The Coal
Authority

Re: Application 2024/44/92949/E

Discharge of conditions 9 (retaining walls), 17 (Phase II Report), 18 (Remediation), 21 (Coal mining) 23 (charging facilities), 24 (facing materials) and 27 (construction management plan) of previous permission 2021/92528 for erection of retail development, associated parking, servicing areas and landscaping at Land off Bankwood Way, Birstall Retail Park, Birstall, Batley, WF17 9DT

Drawing Reference
1080.07 - Figure 02

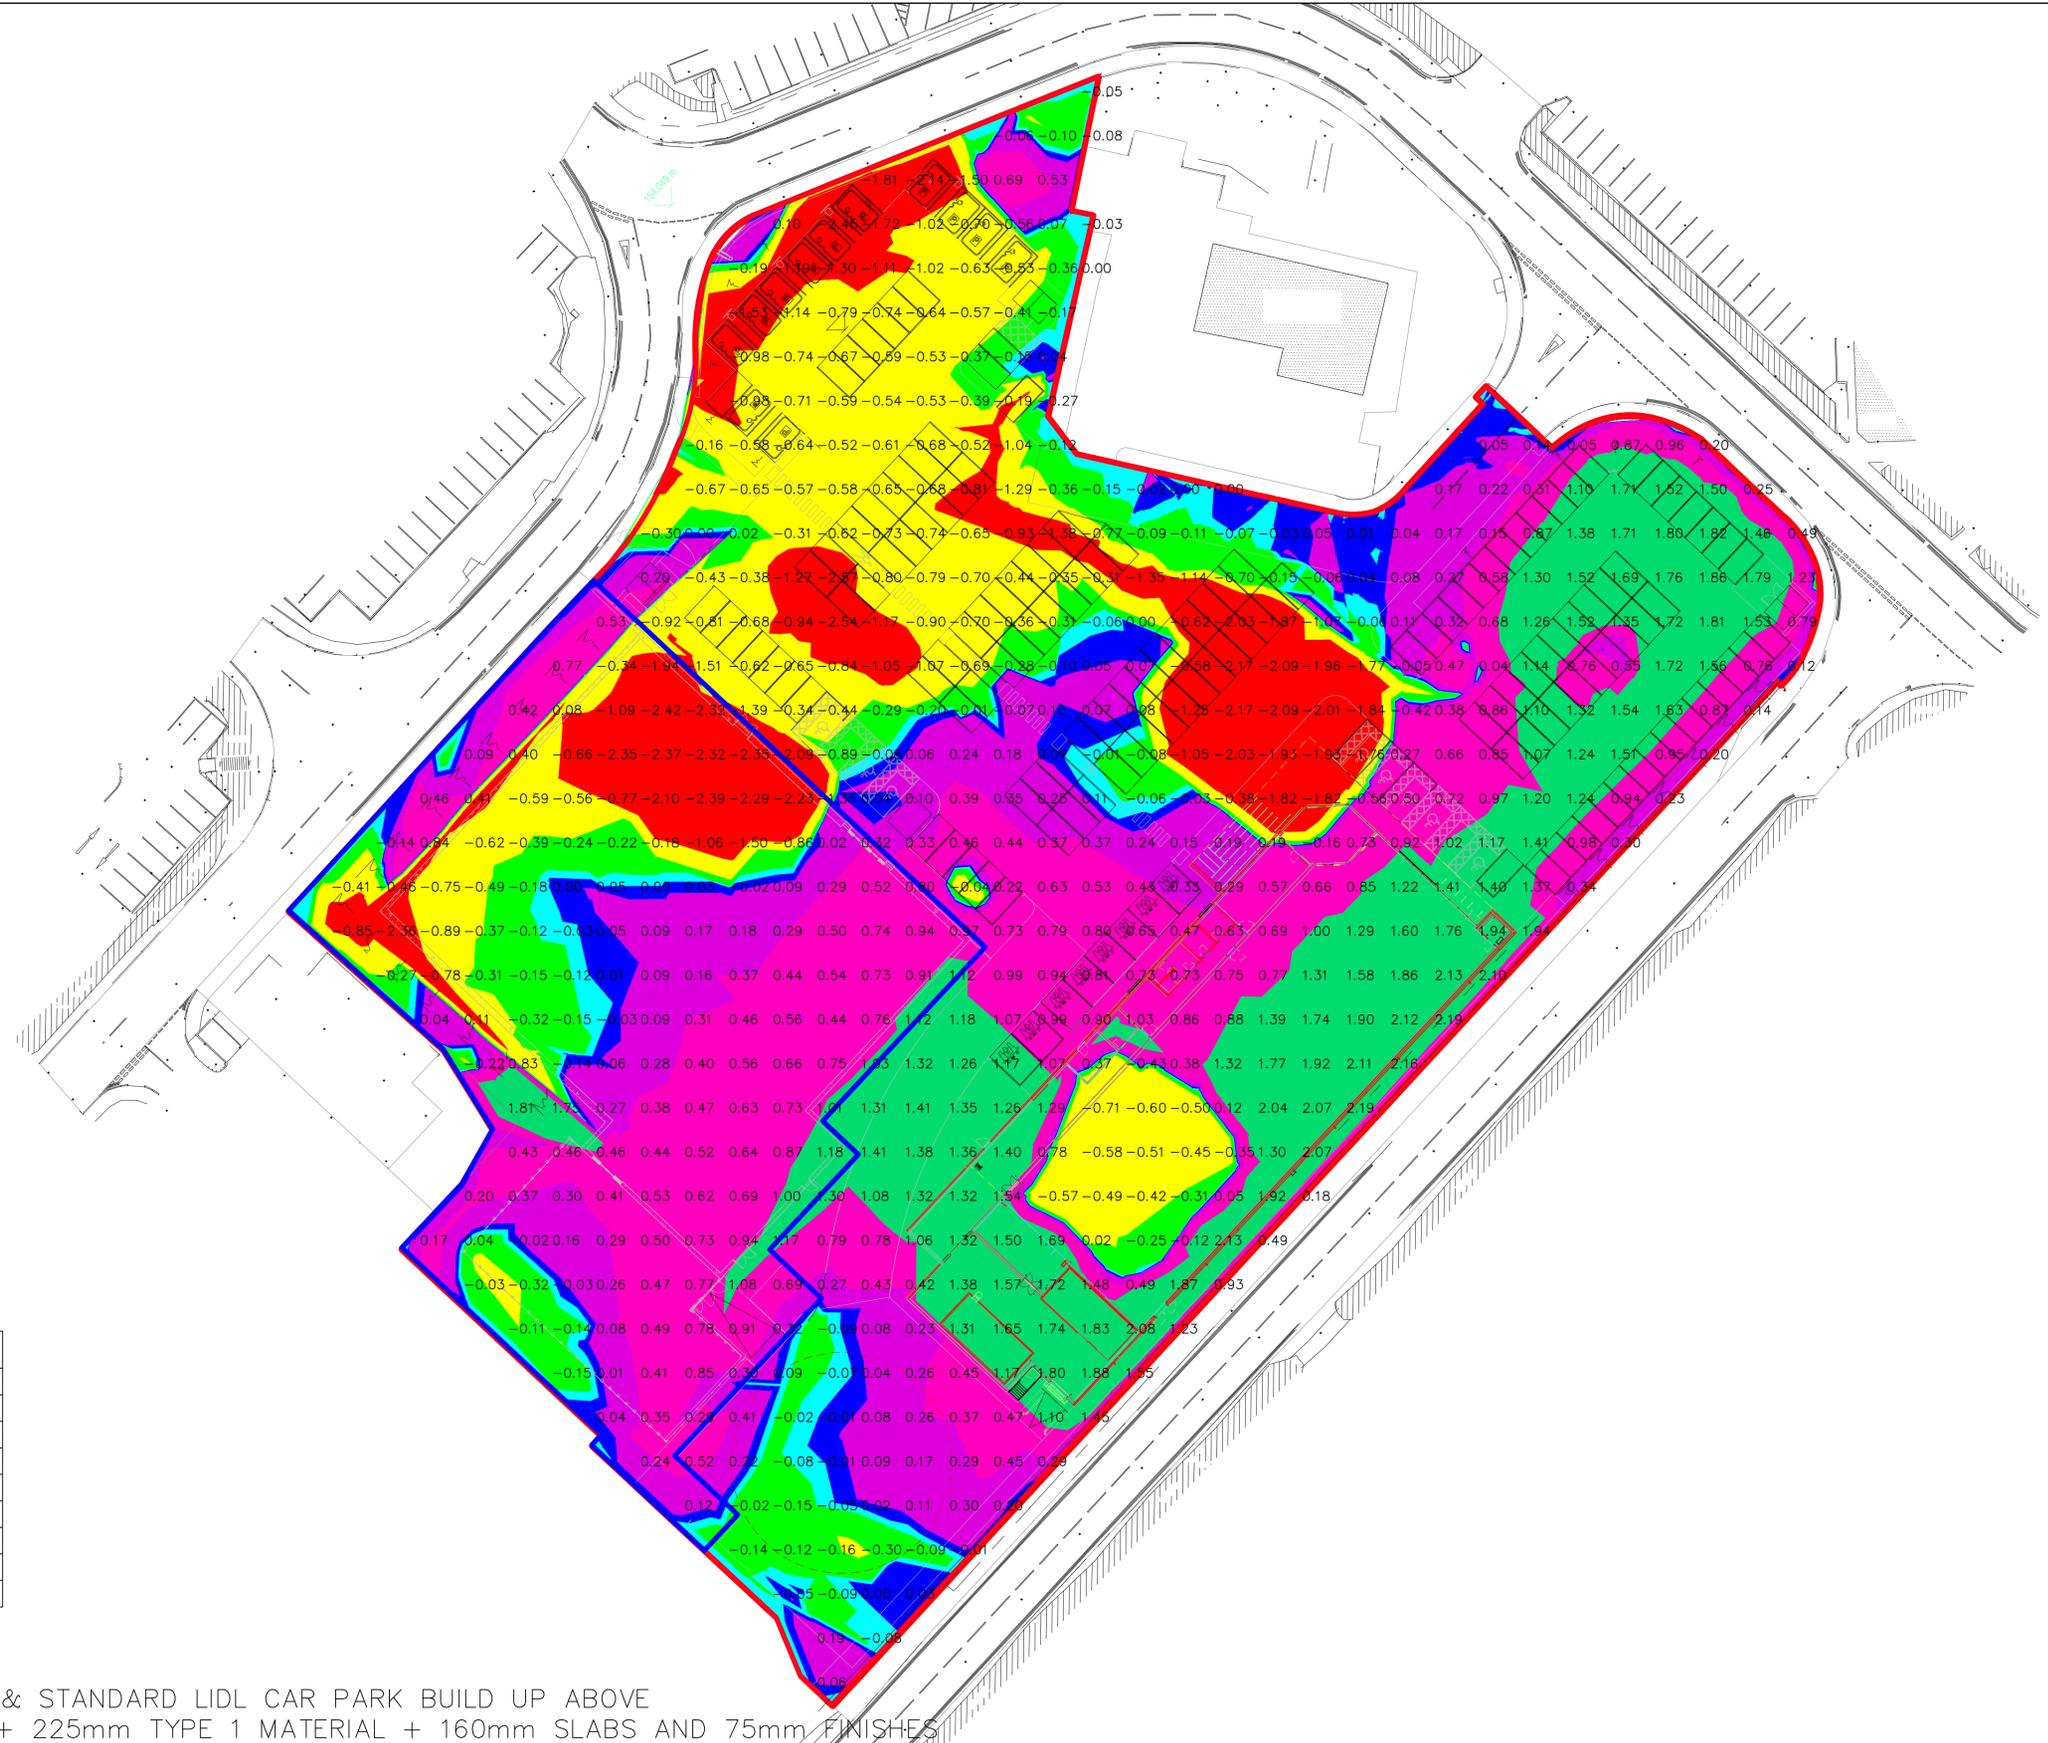
We note that further details of proposed remedial works are included in a Specification for the Drilling and Grouting of Shallow Mine Workings (May 2022, prepared by Sirius) and a subsequent Combined Remediation Strategy, Drilling & Grouting Plan (May 2024, prepared by Remada Ltd). These appear to indicate that the drilling and grouting of workings in the shallow coal seam will take place within those parts of the site where this seam has not been removed by past quarrying activity. The latter report also advises that foundation designs of the buildings should consider the presence of shallow treated/consolidated mine workings.

The Coal Authority's Planning & Development Team welcomes the further investigatory works carried out. We acknowledge the professional opinions expressed regarding the absence of the recorded adit and the anticipated extent of shallow workings which could pose a risk of surface instability. We also welcome the apparent intention to undertake remedial works to stabilise these workings. We wish to highlight that these further works should seek to ensure the stability of not just the built development but also external parts of the site, such as access roads and vehicle parking and manoeuvring areas.

We consider that the first part of Condition 21 has been satisfactorily addressed. However, it is evident that the works required to remediate coal mining legacy affecting the site have not been implemented and as such the second part of the condition has not been complied with. We are therefore unable to recommend that the LPA should discharge Condition 21 of the issued consent at this time.
